Director of Environment & Infrastructure:
Mark Kemp

Date 22 July 2021

RE: 6/2020/3222/MAJ – Former Volkswagen Van Centre, Comet Way, Hatfield, AL10 9TF

David Uncle
SuDS Officer
Flood Risk Management

COMET WAY, HATFIELD
 SURFACE WATER DRAINAGE STRATEGY

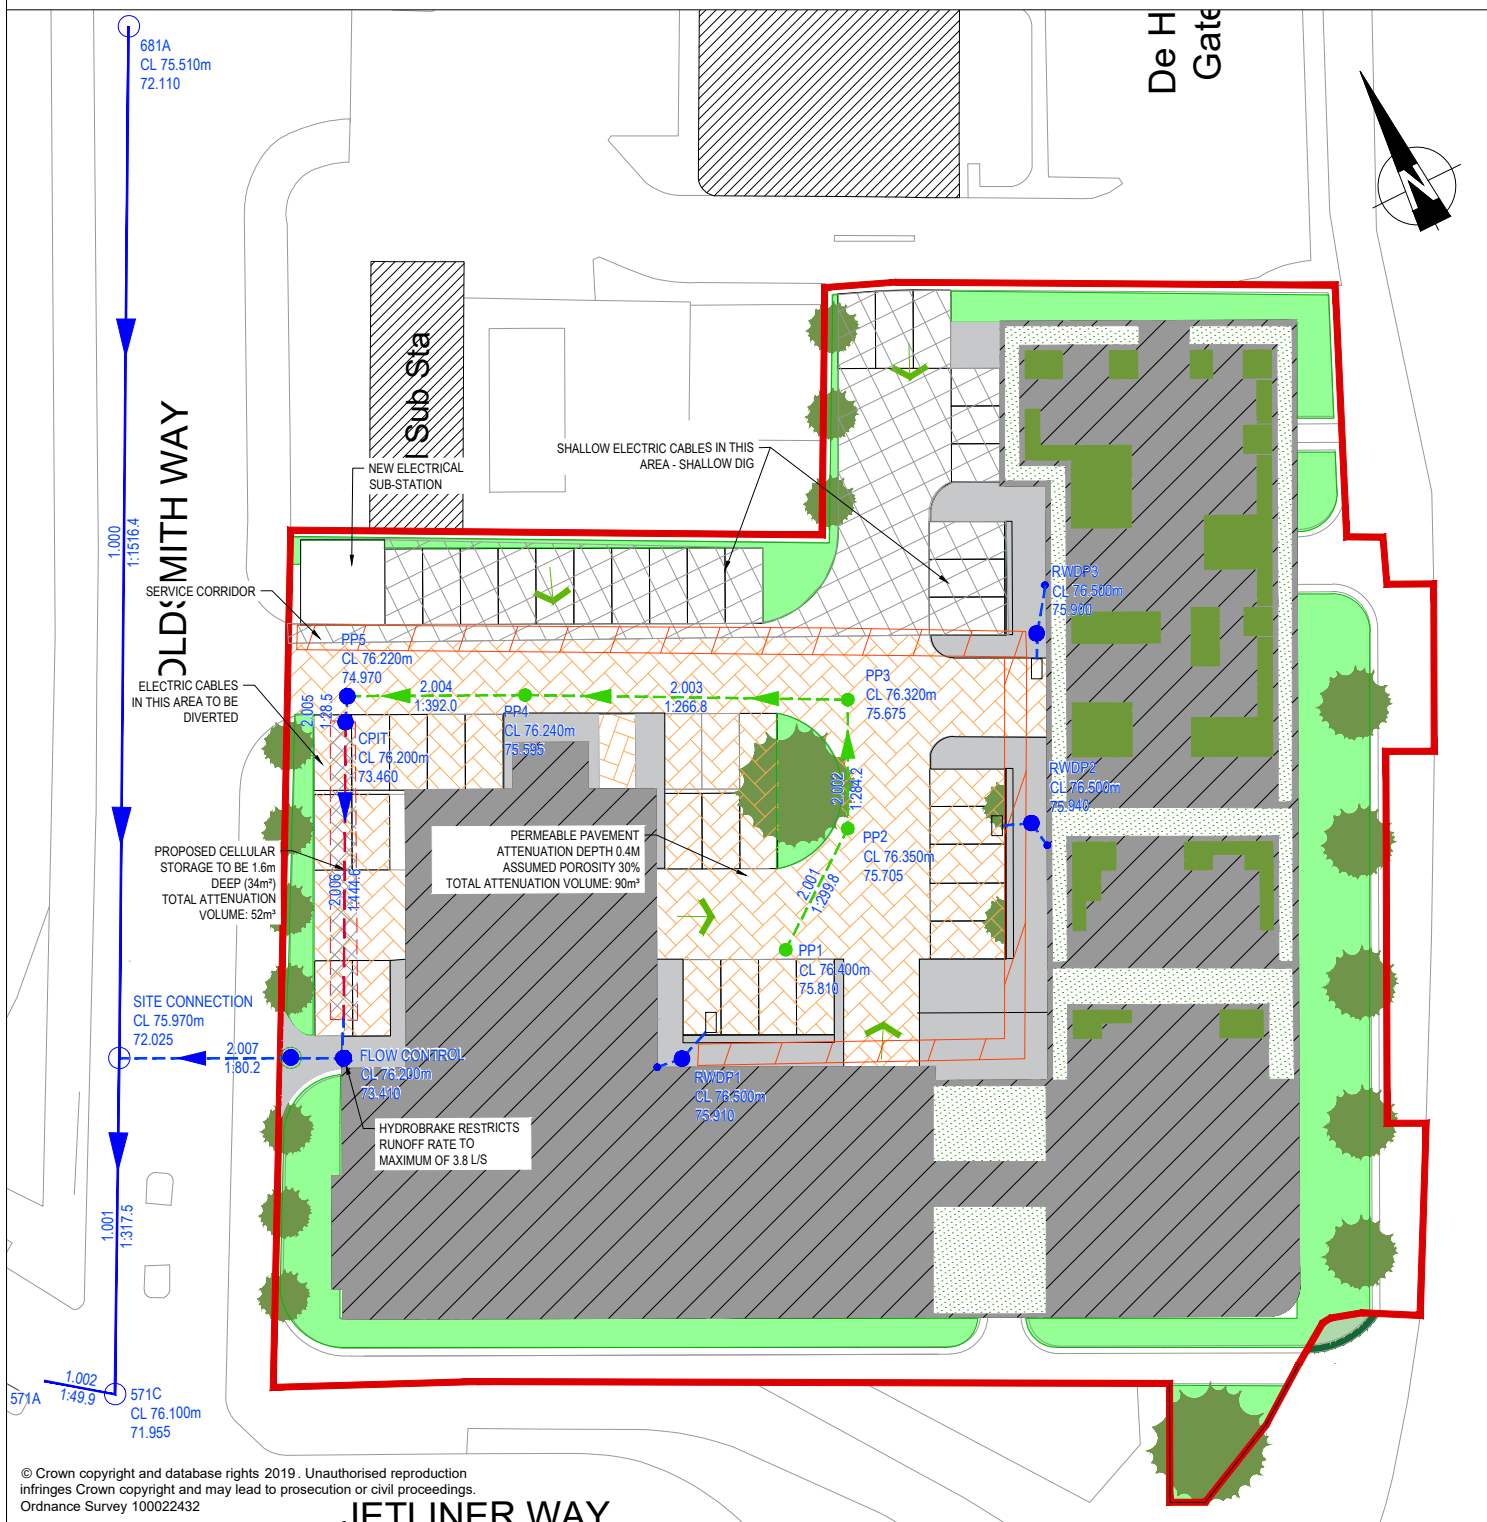
The development permitted by this planning permission shall be carried out in accordance with the approved Proposed Surface Water Drainage Strategy prepared by Stantec, drawing number 47179/4001/002 Revision B dated 20 July 2021, the letter provided by Stantec dated 20 July 2021, and the following mitigation measures detailed within the FRA:

1. Limiting the surface water run-off generated by the critical storm events so that it will not exceed the surface water run-off rate of 2 l/s during the 1 in 100 year event plus 40% climate change event.
2. Providing storage to ensure no increase in surface water run-off volumes for all rainfall events up to and including the 1 in 100 year + climate change event providing

a minimum of 210 m³ (or such storage volume agreed with the LLFA) of total storage volume in permeable paving subbase and attenuation tank.

3. Discharge of surface water from the private drain to the Thames Water sewer on Goldsmith Way.
